**KIRKLEES METROPOLITAN COUNCIL
INVESTMENT & REGENERATION SERVICE**

**DELEGATED DECISION FOR APPLICATION FOR CERTIFICATE OF
LAWFUL DEVELOPMENT**

Reference no.: 2023/CL/92696/W

Site: 56, Greenhill Bank Road, New Mill, Holmfirth, HD9
1ER

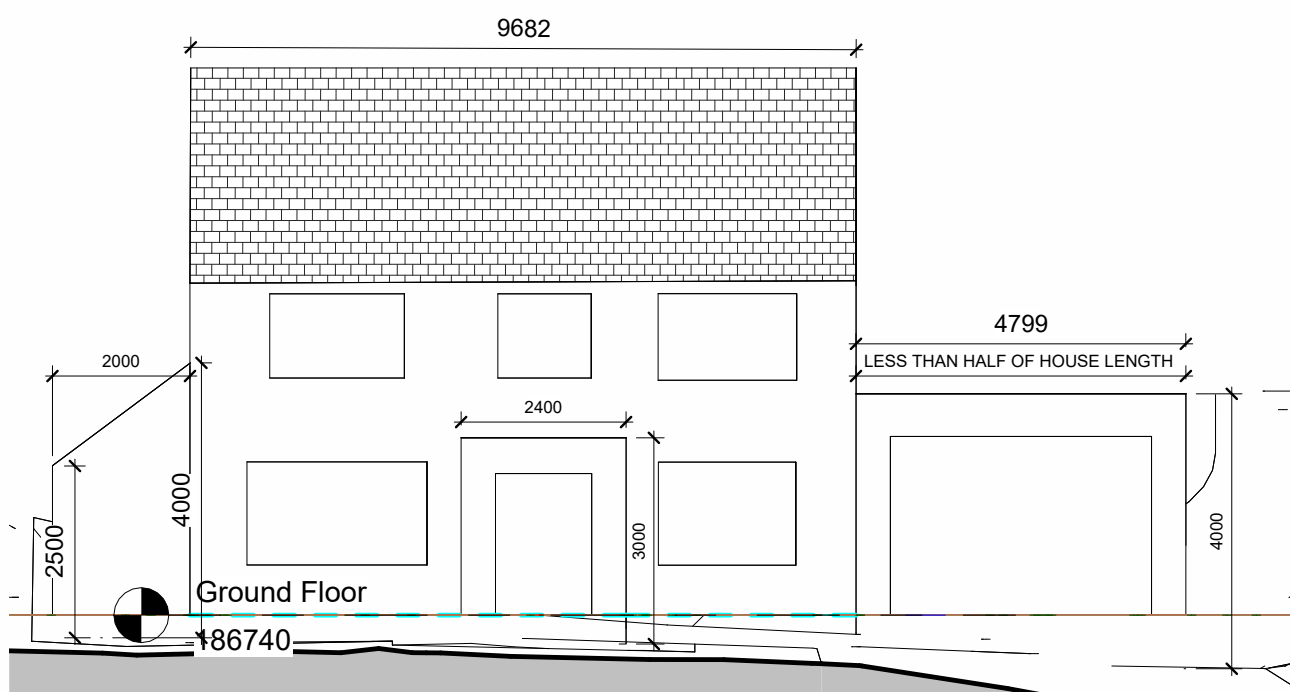
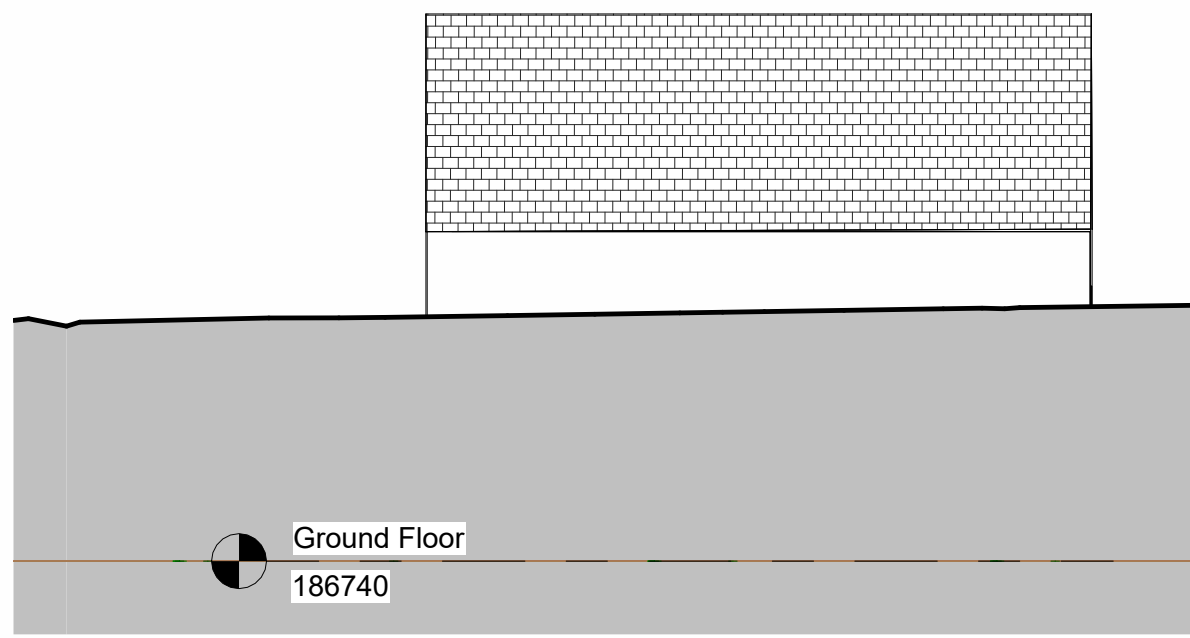
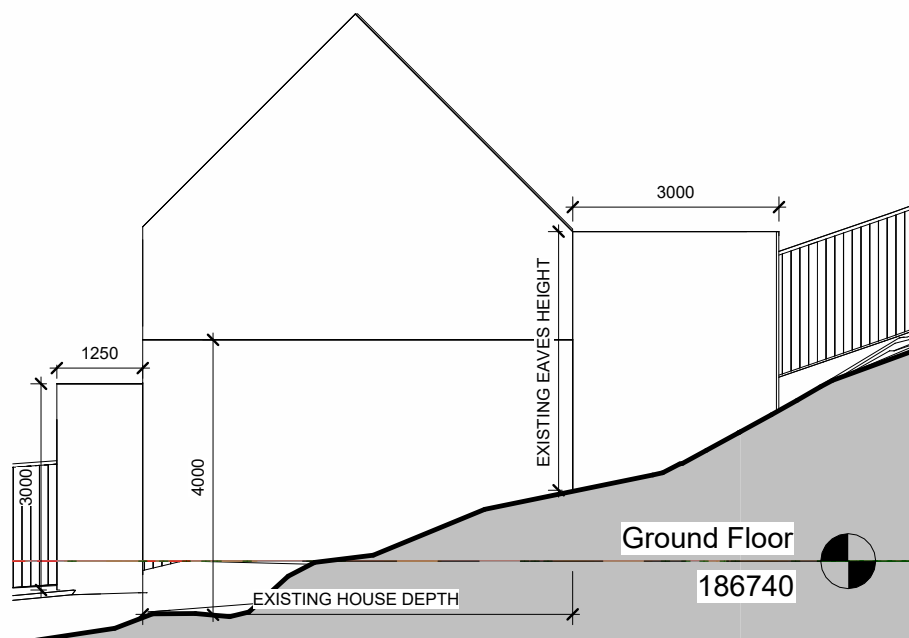
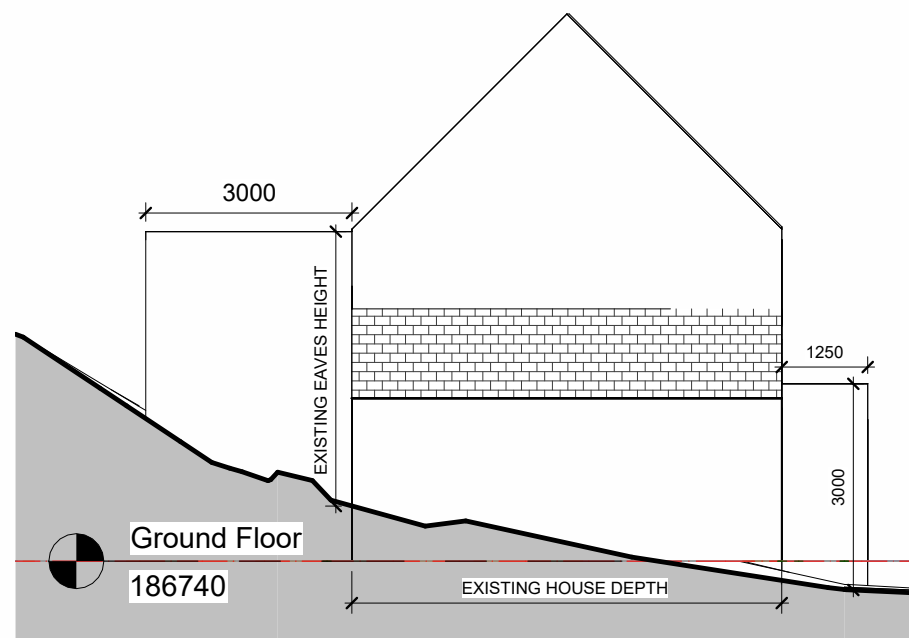
- 2.2 The proposed two-storey rear extension would be the full width of the existing dwelling and project 3.0m. It would have a flat roof which would be the same height as the eaves.

- 2.3 Two single-storey side extensions are also proposed. The one to the north elevation would be 4.799m in width and would form a garage with a flat roof. The one to the south would project only 2m from the side wall and would have a lean-to roof. A small existing detached garage would be removed to facilitate this.

- 2.4 A small porch is shown on the plans as proposed, placed in the centre of the front elevation, which would measure 1.25m by 2.4m externally and be 3.0m high (with a flat roof).

Comment: The supporting statement confirms that the rear extension will be two-storey and from scaled measurements on the site plan it can be ascertained that it would be more than 7m from the rear boundary and would not extend more than 3 metres from the original dwellinghouse.

Comment: The side extension to the dwellinghouse would be within 2m of the original boundary of the curtilage of the dwellinghouse but eaves height, measured from the highest part of the adjacent ground level, would not exceed 3m.

Comment: The proposed side extension would not exceed 4m in height, would not have more than a single storey, and would be less than half the width of the original dwelling house.

Comment: The plans do not indicate any upper floor windows. Clause (c) does not apply because the proposed rear extension has a flat roof.

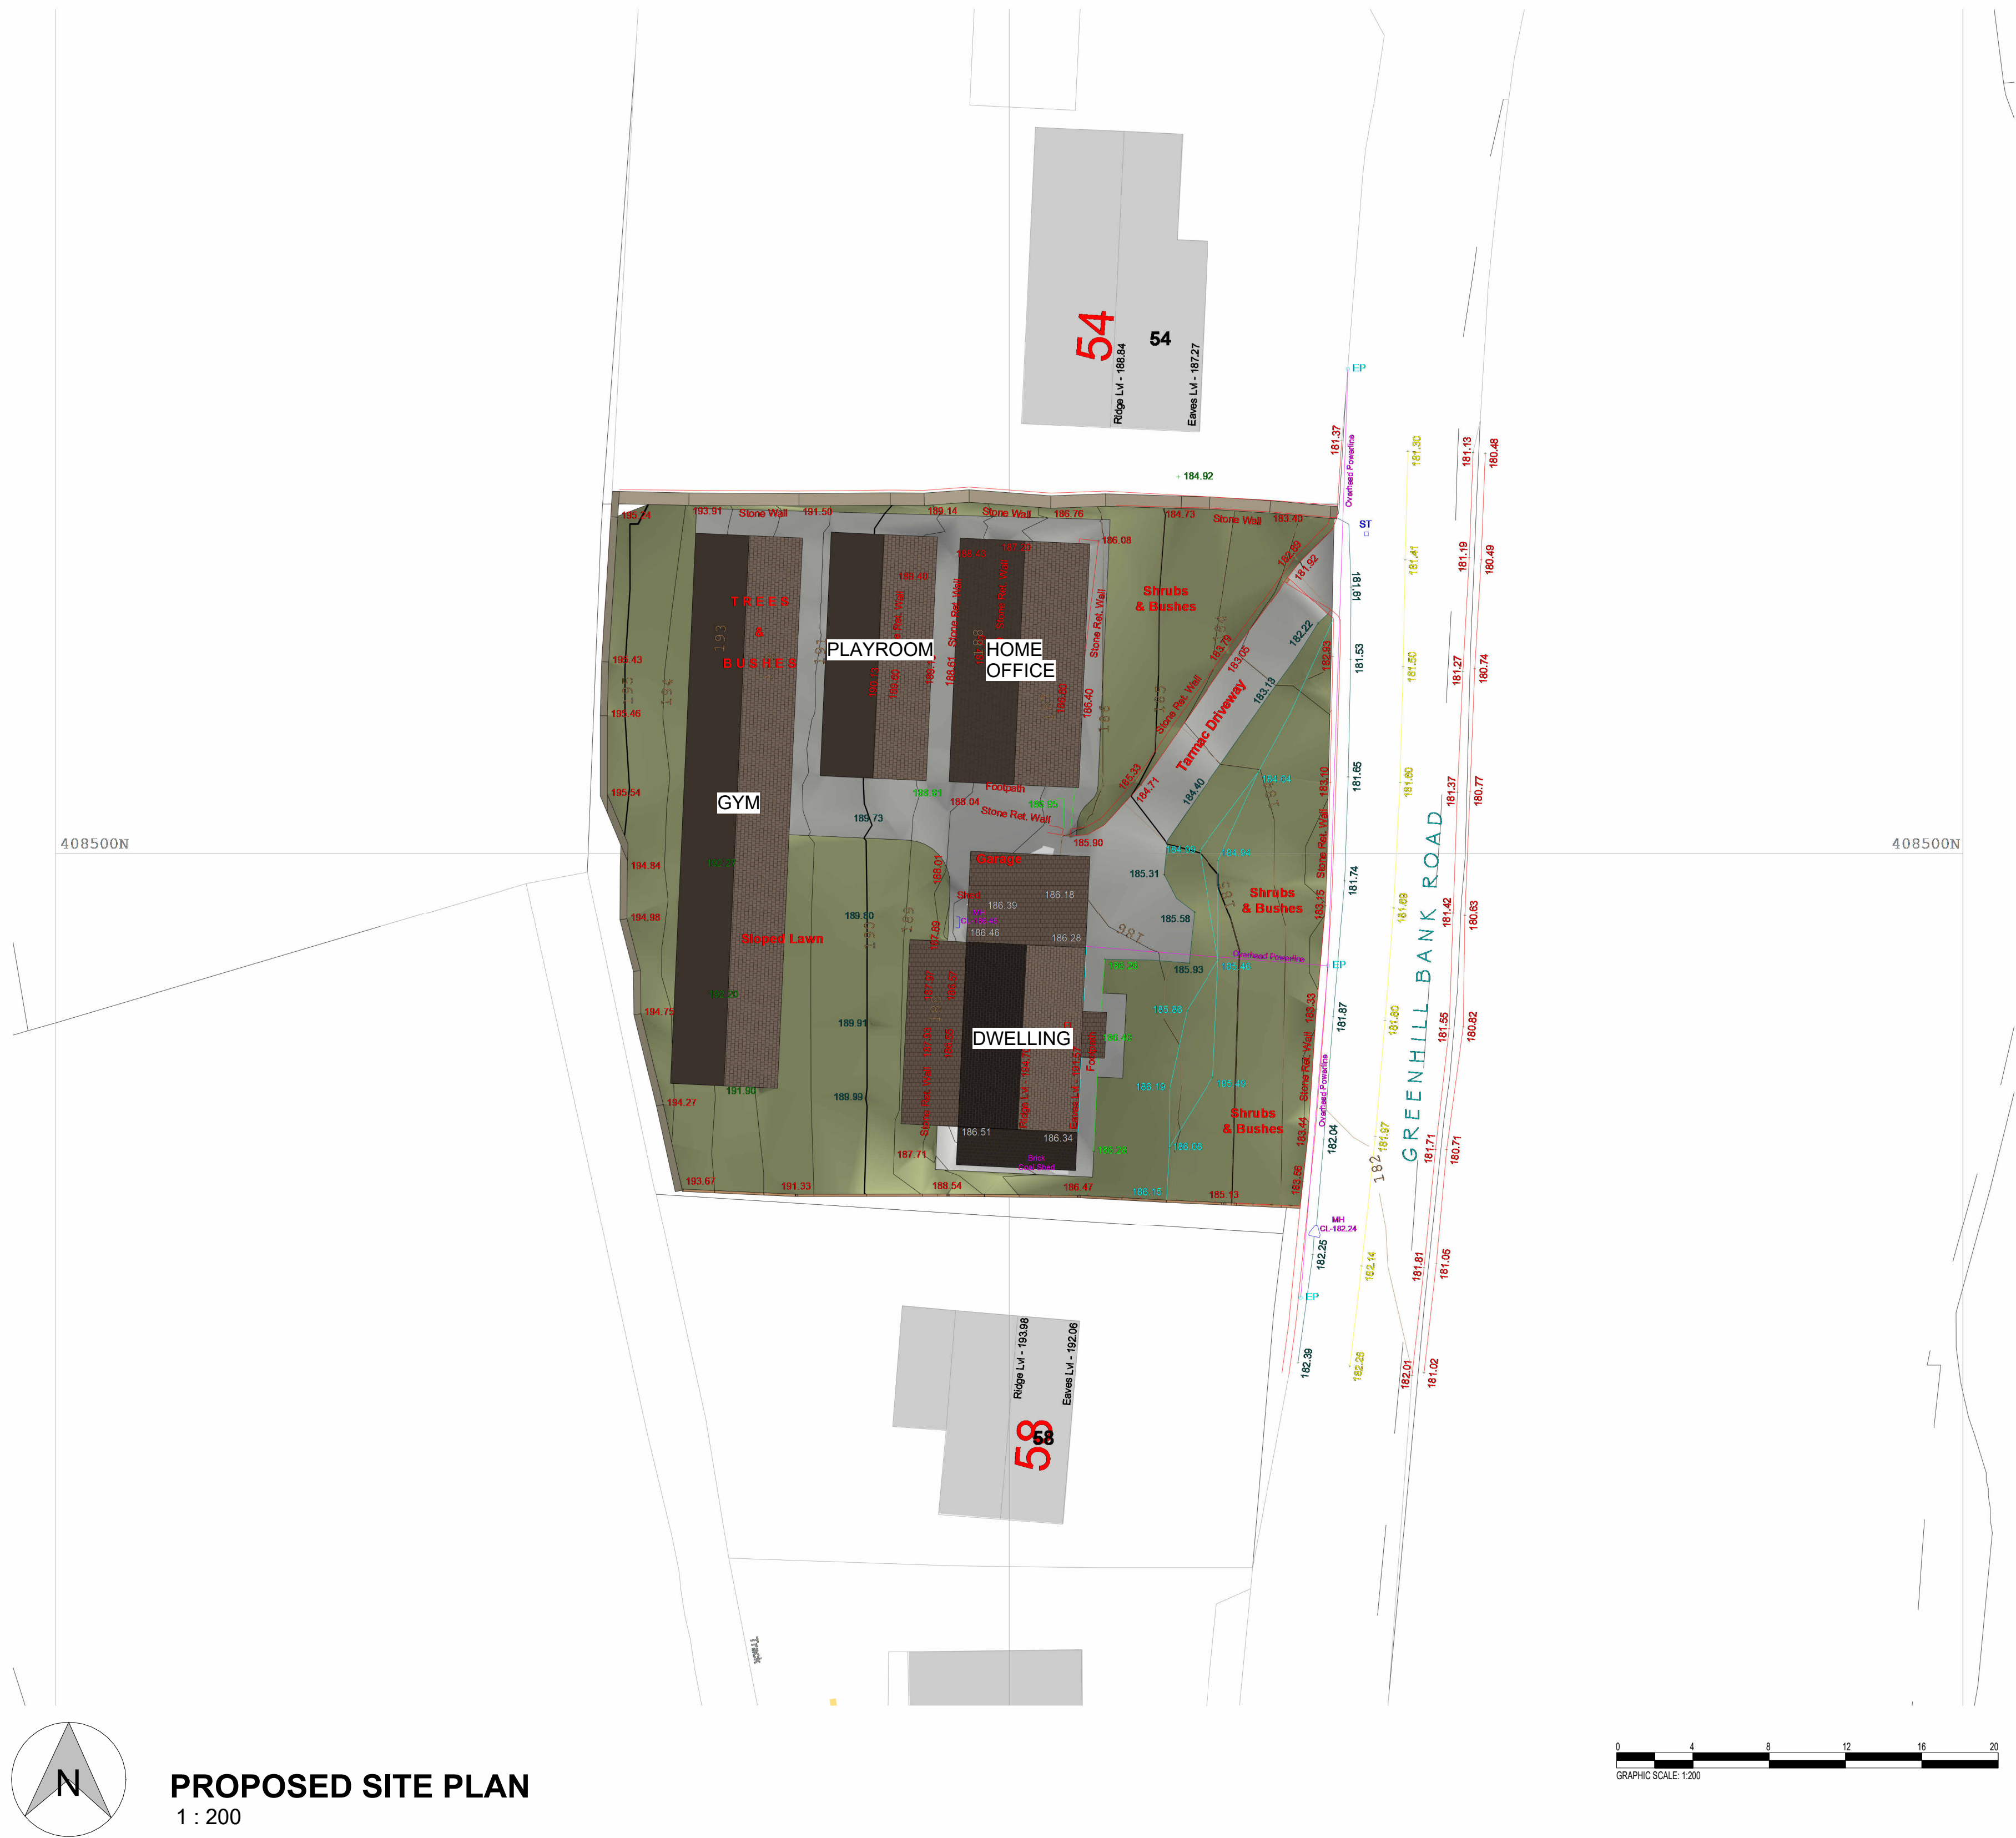
- 6.14 Returning to the present case, the aggregate footprint of the three proposed outbuildings would have a footprint of 264sqm. This is approximately 500% the footprint of the existing dwelling (before any extensions), which, this being a two-storey dwelling, would be equivalent to 250% of the existing floor area. The cumulative footprint of the three outbuildings would in fact substantially exceed the footprint of the dwelling as extended under the proposed scheme. Looking at the outbuildings individually, it is considered that they all three are exceptionally large for the stated uses to which they are to be put, given the size of the property. The applicant has not provided any evidence to demonstrate why the buildings are required to the proposed size and it is therefore considered a functional gym and playroom for family could each be reasonably accommodated in a much smaller building. It would therefore appear the size of the gym and playroom is unrestrained and unjustified. The home office is also of a significant size which questions whether it can be considered incidental to the enjoyment of the dwellinghouse particularly as the size would allow accommodation of a significant number of work desks/meeting rooms etc which may suggest a separate office use beyond an incidental use one could ordinarily expect at a dwellinghouse.

- 6.15 The scale of the outbuildings proposed is therefore considered to be exceptional for a domestic setting, taking into account the modest size of the dwelling they would serve, and of the residential curtilage in which they would be placed. No written evidence has been supplied to demonstrate that the buildings are required for purposes that are ordinarily and reasonably incidental to the enjoyment of the dwelling, or that a smaller building or buildings would fail to adequately serve the same need. It is therefore considered that
